Reference No:	2022/62/93109/E
Site Address:	220, Partridge Crescent, Thornhill, Dewsbury, WF12 0HW
Description:	Erection of two storey side and single storey front extensions including external alterations
Recommending Officer:	Nicole Helliwell

DECISION – Conditional Full Permission

Officer Report

Reference No. 2022/62/93109/E

Drawing No: 2209/112 Rev:

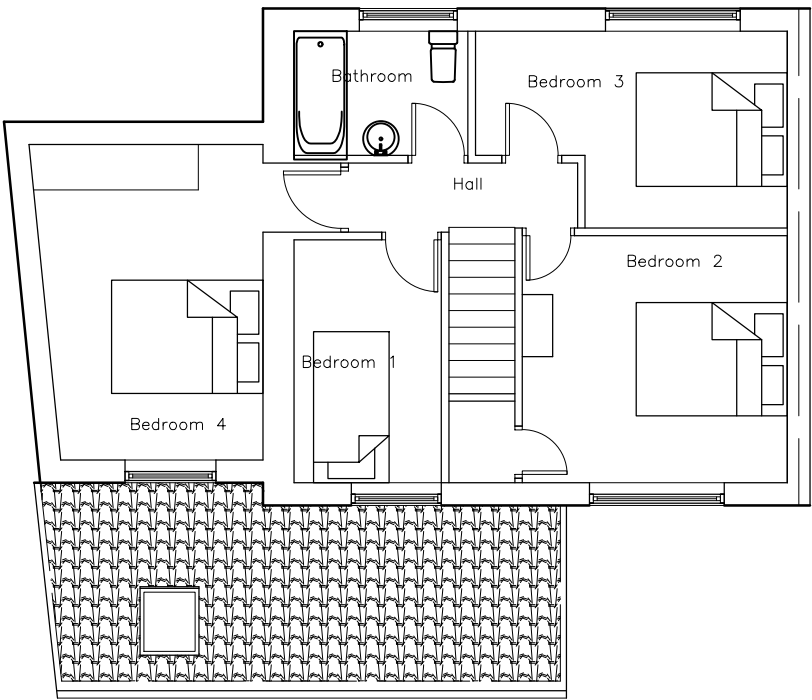
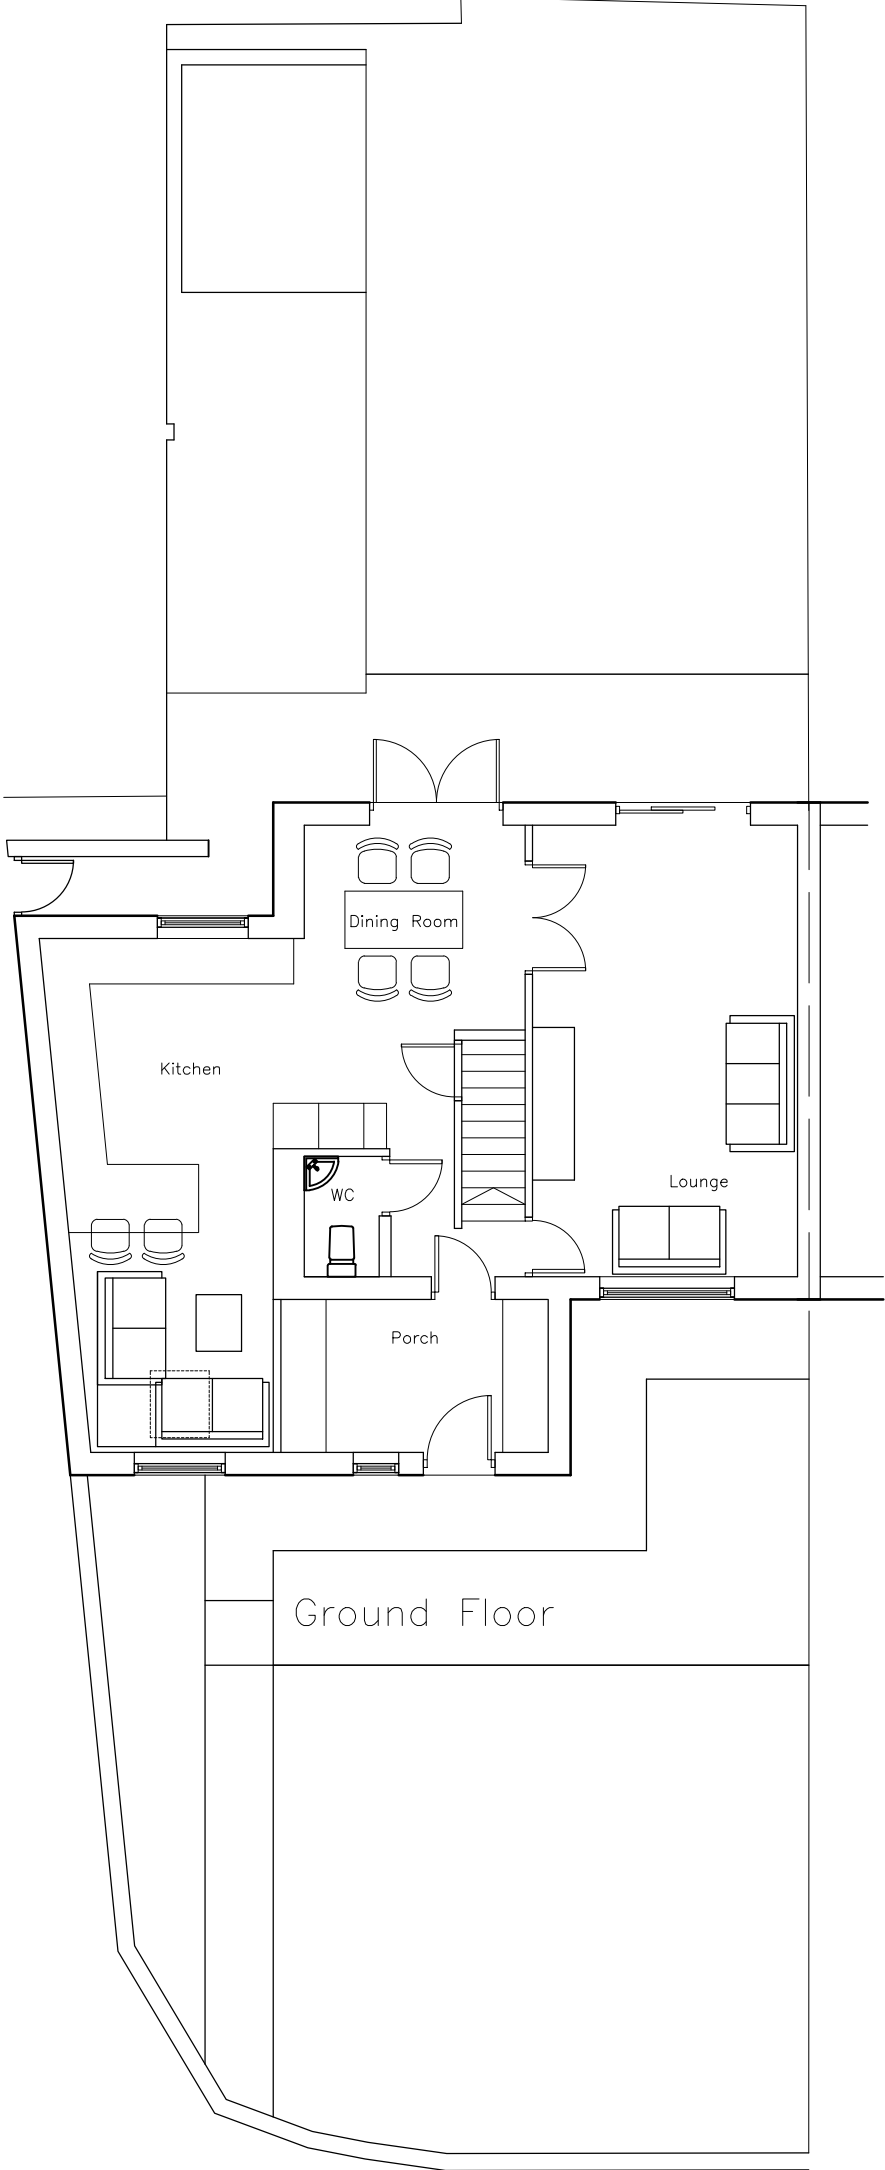
The proposed single storey front extension would extend approximately 2.3m from the front elevation of the original dwellinghouse. The enlargement would incorporate a mono-pitched roof and would be finished in a material palette to match the appearance of the host property. Although the extension would have a large scale, it would maintain a distance of approx. 8.8m to the pavement, which would reduce its prominence from public vantage points. Furthermore, documentation was submitted to evidence that the proposal would help to support the applicants' medical needs. In this instance, it was considered that the personal benefit created would outweigh any harm to visual amenity.

222 Partridge Crescent is a residential dwelling sited to the rear of the application site. The submitted plans confirm that the proposed two storey side extension would not contain any rear fenestration at first floor level and

would measure approximately 12m to no.222. Whilst the neighbouring property contains a first floor window on the front elevation, it is noted that the window is obscure glazed and serves an ensuite, which is a non-habitable room. Therefore, it is considered that there would be no undue harm to the neighbouring occupants with regard to overlooking, overshadowing and overbearing impact.

218 Partridge Crescent is a two storey property located east of the application site. The plans confirm that the proposed single storey front extension would be positioned approximately 3.15m away from the common boundary shared with no.218 and would accord with the 45-degree rule in relation to the neighbour's ground floor windows. Furthermore, it is noted that the proposed two storey side extension would be located at the opposite side of the dwellinghouse and would not surpass the neighbour's front and rear elevations. On this basis, it is considered that the proposed development would have an acceptable impact on the neighbour's residential amenity.

Amendments were sought during the course of the application. A request was made to alter the projection of the proposed single storey front extension to 1.6m. This was to reduce its prominence from public vantage points given that the street scene is devoid of front extensions. Although revised drawings were not received, documentation was submitted to evidence that the proposal would help to support the applicants' medical needs. On this basis, it was considered that the personal benefit created, and taking into account the design of the proposal, would outweigh any harm to visual amenity.

Client: Mr & Mrs A Hudson	
Project: 220 Partridge Crescent Dewsbury WF12 0HW	
Drawing: Proposed Location and Layout	
Date: Sept 2022	Scale: 1:200 @ A3
Drawing No: 2209/110	
Rev:

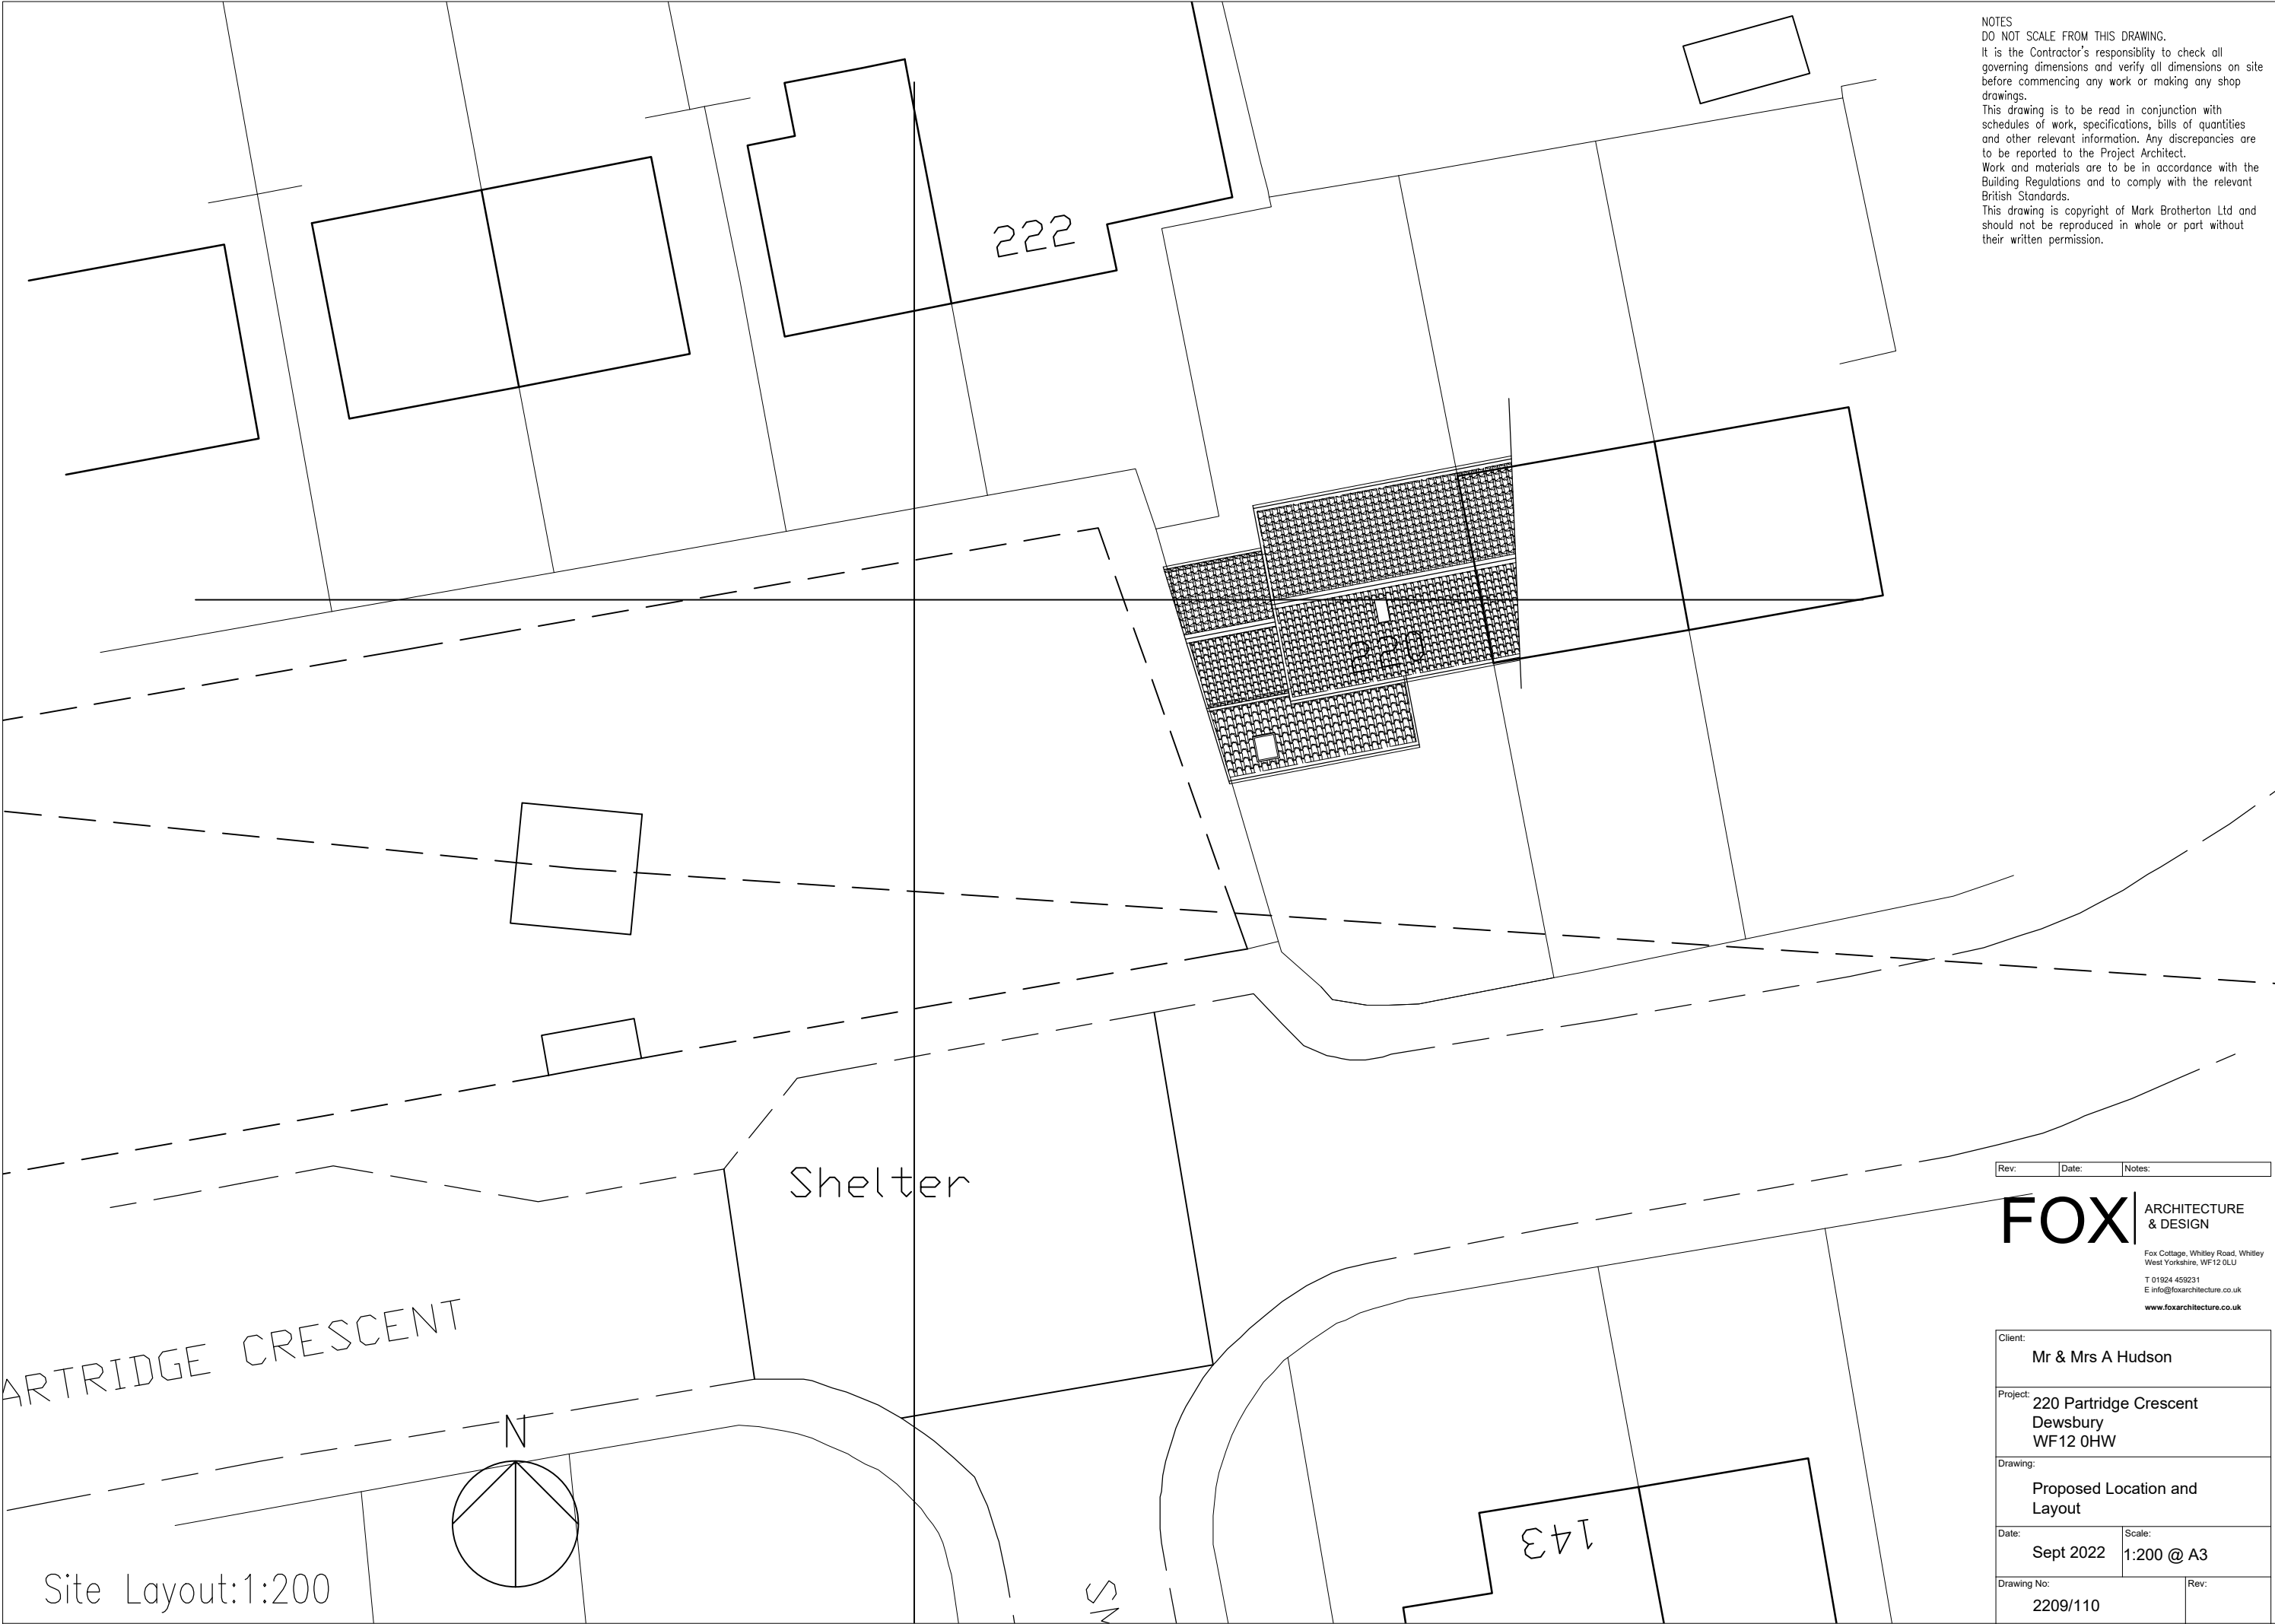
The proposed two storey side extension would be built in line with the western boundary. The enlargement would incorporate a dual pitched roof and would be faced in pebble dashed render to match the appearance of

the host property. The extension would also feature a lower ridge line and would be set back from the principal elevation at first floor level. Although the extension would encroach the building line and would fail to retain 1m to all property boundaries, it would be a subservient addition and would maintain a sense of space within the plot. Due to the siting of the neighbouring property, set well back in relation to the application property, the proposal would not have the effect of 'closing the gap' as would be found with a traditional building line. Therefore, it is considered, on balance, that the proposed development would respect the visual amenity of the host dwelling and neighbouring properties and would be acceptable in this regard.

The plans confirm that sufficient outdoor amenity space of a functional layout would be retained at the site. On this basis, the proposed works would ensure an acceptable standard of amenity for existing and future occupants.

The proposal would create an additional bedroom, which would intensify the domestic use at the dwelling. Although it is noted that the House Extensions and Alterations SPD requires three off road parking spaces for a four bedroomed dwellinghouse, it is considered that cumulatively the existing hardstanding and pathway to the front of the property could support three vehicles. Therefore, on balance, the proposed development is considered acceptable in accordance with Policies LP21 and LP22 of the KLP, Chapter 9 of the NPPF, Principles 15 and 16 of the Kirklees House Extensions and Alterations SPD and the Highways Design Guide SPD.
